**From:** Katherine Rawlins  
**Sent:** 16 November 2011 09:30  
**To:** 'lloyd willson'; Harry Bud 11 Ivydale  
**Subject:** RE: BR/249/11/

I refer to the above planning application at 11 Ivydale Road, Bognor Regis, PO21 5LX for the addition of extensions and dormer windows.

Proposed West Elevation

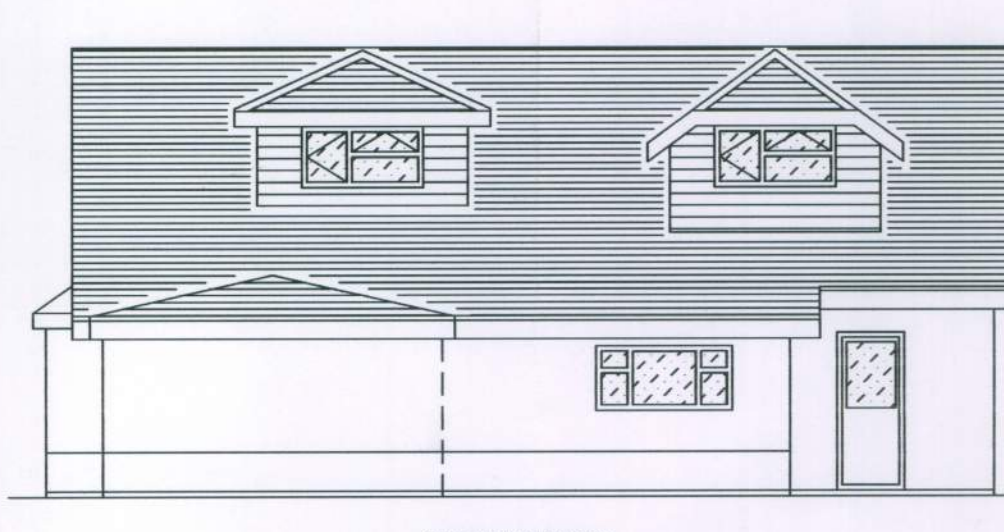
Having discussed the application with my Team Leader, the proposed front and rear extensions, and the addition of dormer windows are considered acceptable in design and visual amenity terms. However, the proposed side extension with a hipped roof adds significant bulk and massing to the property and is considered unacceptable in design terms. From the submitted floorplans the garage at ground floor level is extremely narrow in width and would be unable to accommodate a car.

Please could you therefore amend the drawings by omitting the side extension and inserting an additional hipped roof dormer window on the west facing roofslope. On receipt of amended plans, the officer recommendation will be to approve the application.

We have taken on board your comments and have amended the designs. We have reduced the barn end roof over the garage and included an additional dormer. We require the garage space even though a car would not fit in and included in the proposed application. We would use the space as per the current usage for storage. We intend using Santoff 20/20 roof tile to match the existing. The new roof line is as I am sure you will agree less over bearing.
